15 February 2017

File Number: SSD 7684
Our Ref: 2017/064739

**CONCEPT PROPOSAL FOR THE REDEVELOPMENT OF COCKLE BAY WHARF
– 241 – 249 WHEAT ROAD, COCKLE BAY (SSD 7684)**

PHOTOMONTAGES FROM THE EIS ILLUSTRATING THE RELATIONSHIP OF THE TOWER BUILDING WITH PYRMONT BRIDGE, THE WATERS OF DARLING HARBOUR AND THE EXISTING DARLING PARK BUILDINGS

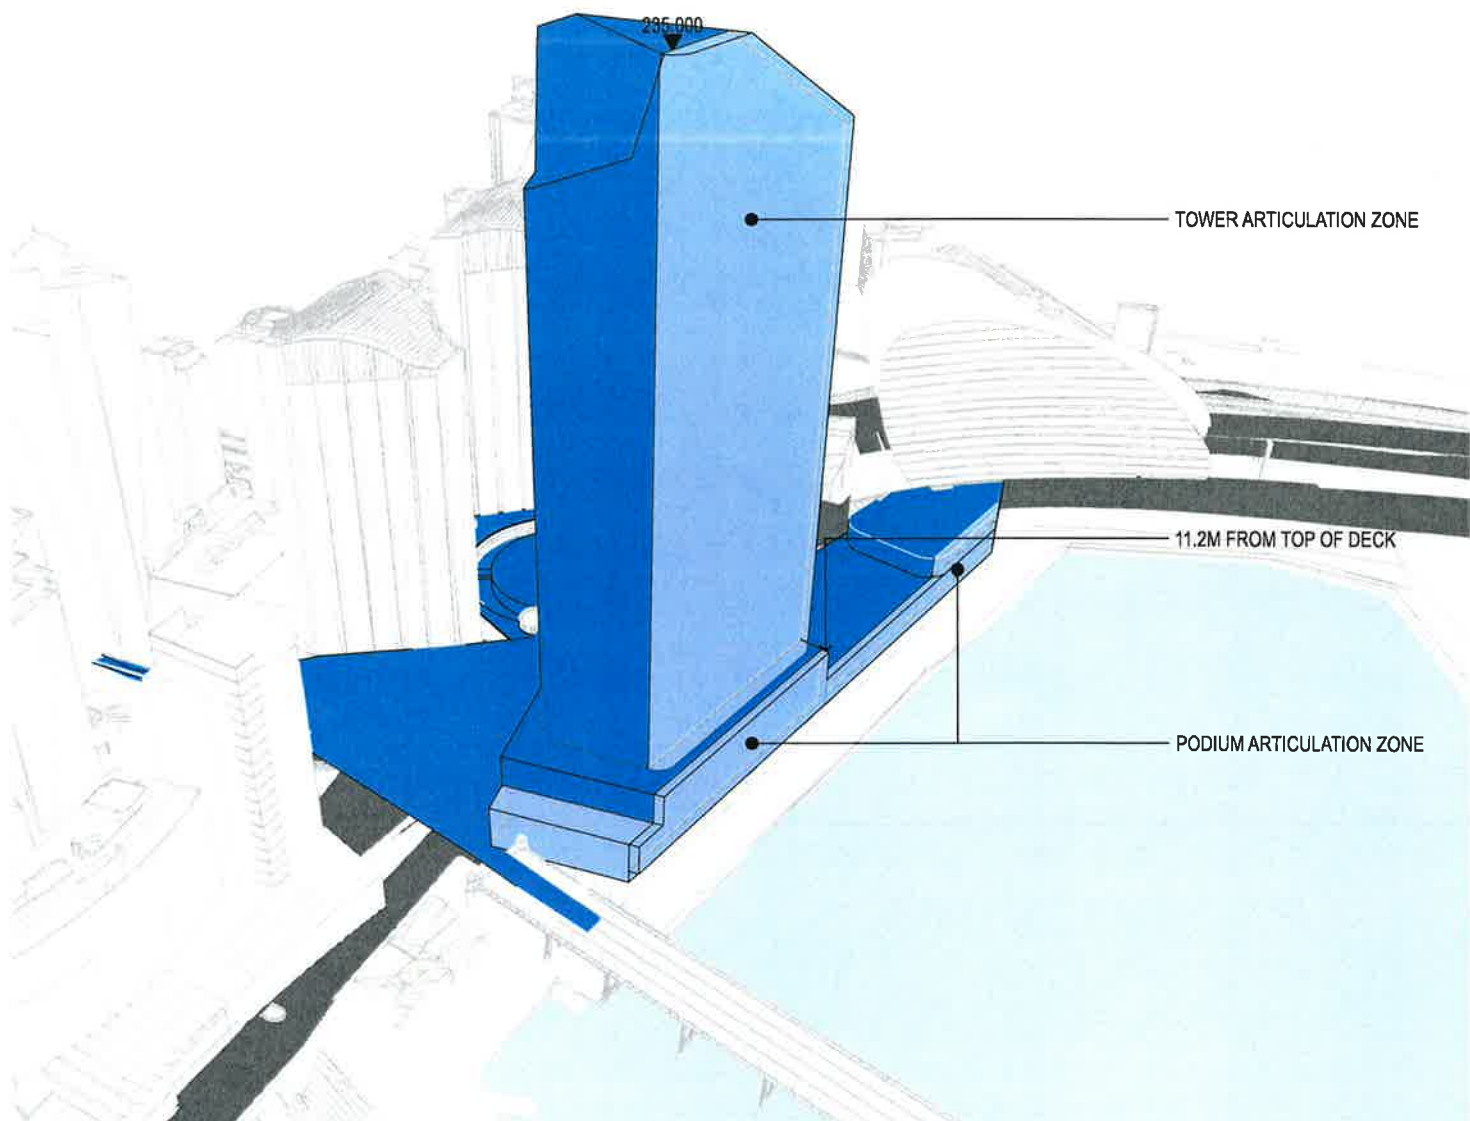
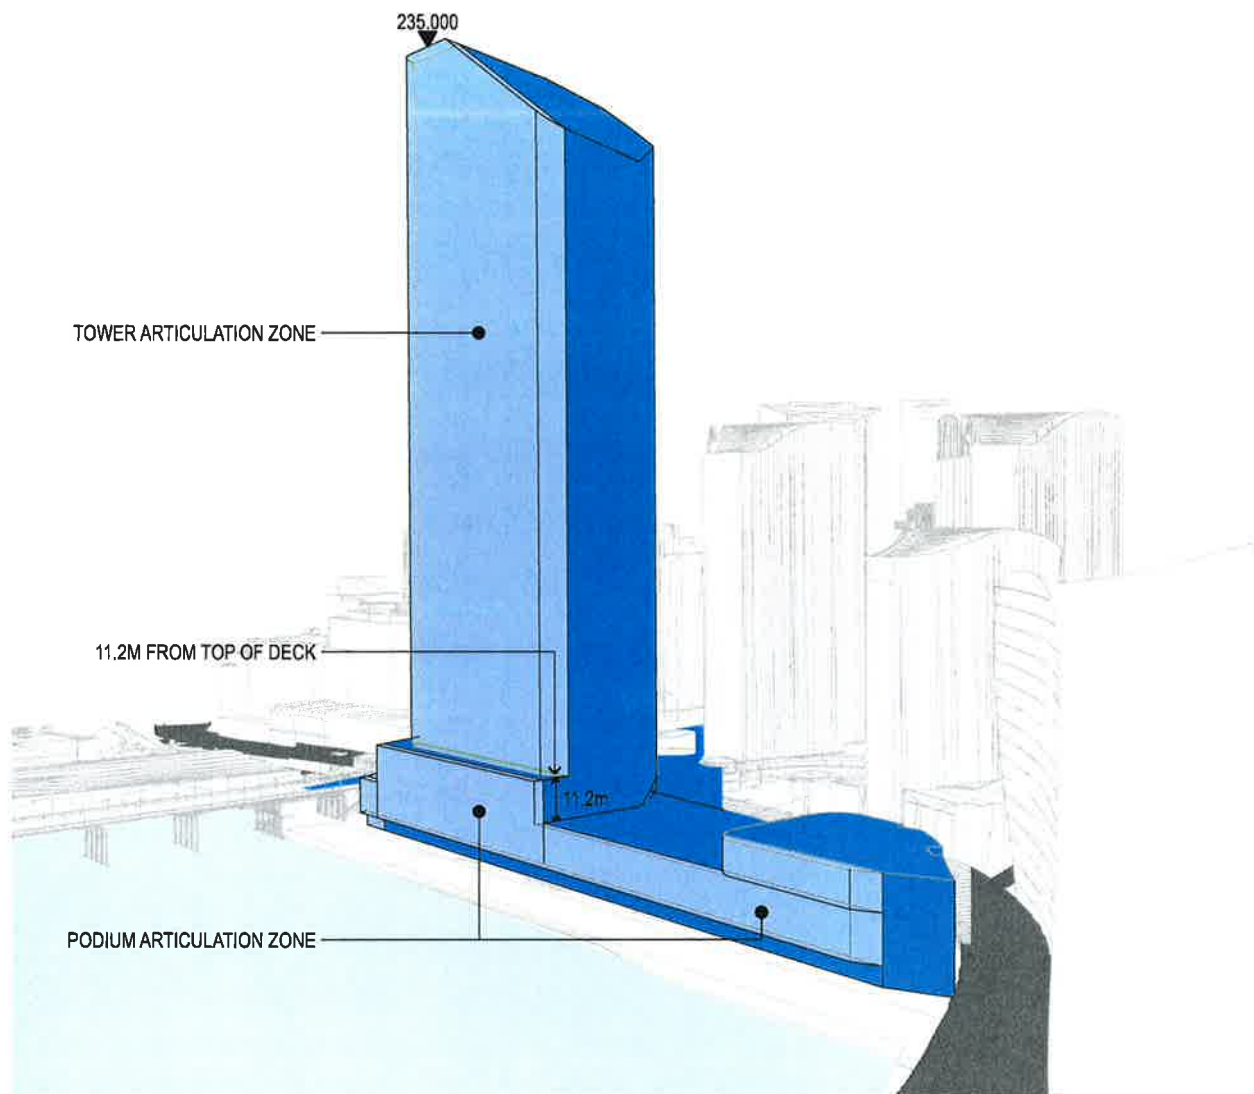
The proposal shows an aerial pedestrian bridge extending from Market Street/ Darling Park over the eastern section of Pyrmont Bridge. This is an unacceptable impact on the form and fabric of Pyrmont Bridge. The clear rectangular form of the Pyrmont Bridge deck is one of Sydney's finest pedestrian promenades. In recent years, it has significantly benefitted from the demolition of the intrusive monorail line. The proposed link is wider and bulkier than the demolished monorail and would have a more negative impact on the heritage significance of the bridge. The structure of the new bridge link is not resolved and it is unlikely that it could be borne by the timber trusses of Pyrmont Bridge without intrusive and negative interventions into the existing fabric. The visual analysis of the Public View Photomontages demonstrate a very significant negative impact.

The section of the proposed bridge link that impinges on Pyrmont Bridge is to be deleted. Any pedestrian link to Pyrmont Bridge must be physically and structurally separate from Pyrmont Bridge and minimise visual and physical impacts to Pyrmont Bridge. Pedestrian connections to Pyrmont Bridge are to be at the grade of the existing main bridge deck.

future Town Hall Square - STEREOGRAPHIC MAPS

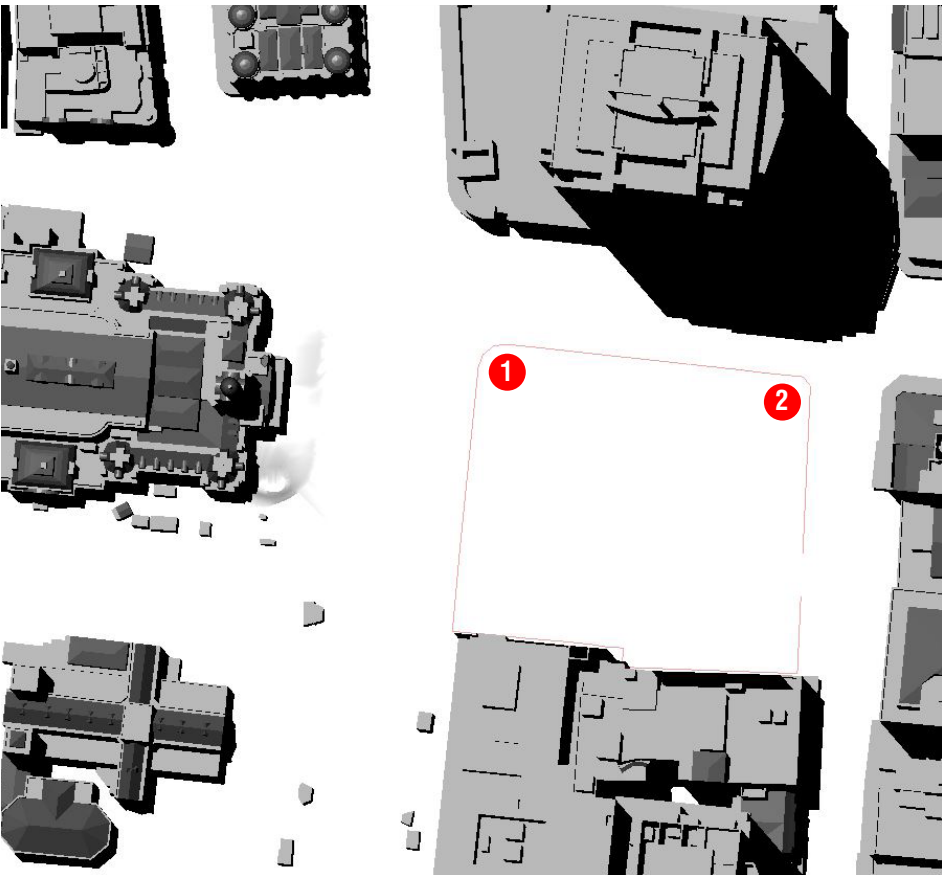
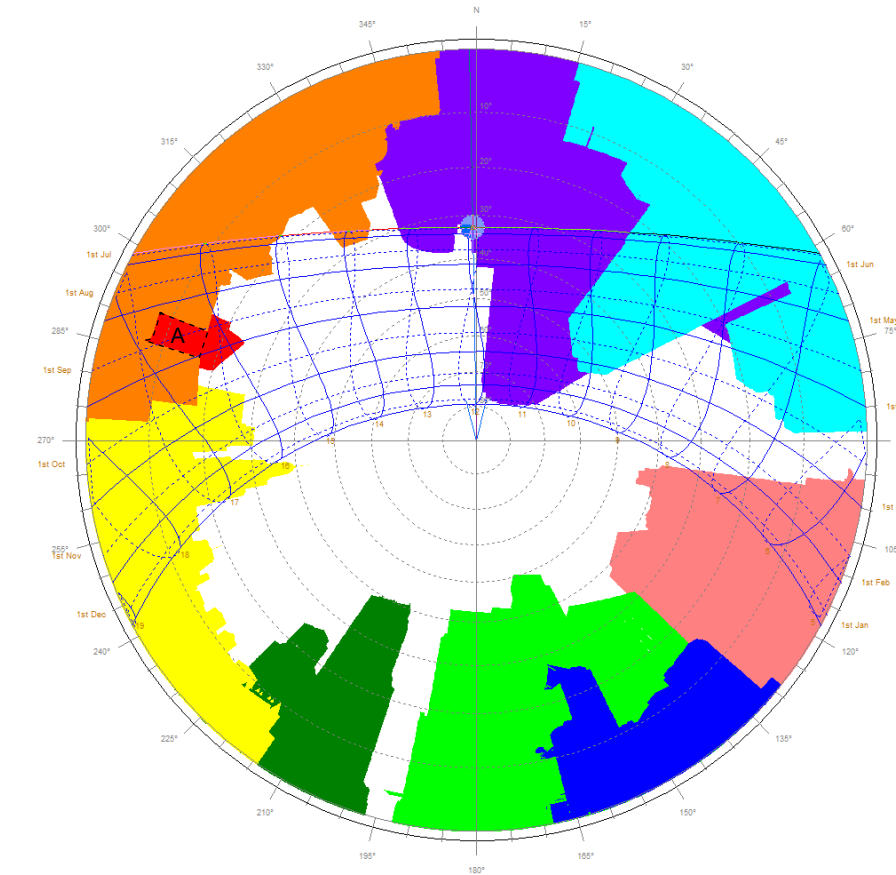
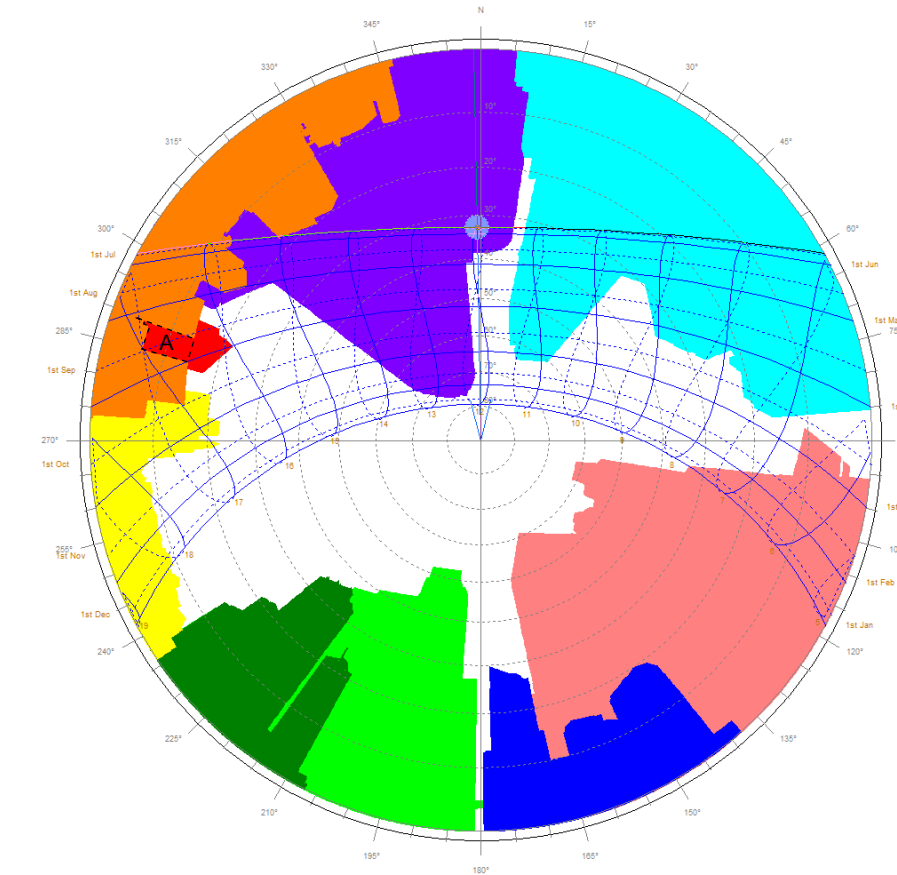
In regard to the Town Hall Square the City has analysed a grid of nine points and found that the northern and eastern parts are most affected and the southern and western parts are less affected. In the afternoon, the impacted times of the year will be in mid-Autumn (from the beginning of April to late April) and in mid-Spring (from mid-August to mid-September).

Presently the future square would receive approximately 3.75 hours of sun in the afternoon. The proposal will overshadow the square during these times of the year for various durations generally between 3.45pm to 4.30pm. This represents a loss of up to 20% of useful sun during these important times of year. Most affected is the north east corner of the square which will lose up to 25% of its direct after-noon sun at these times of year.
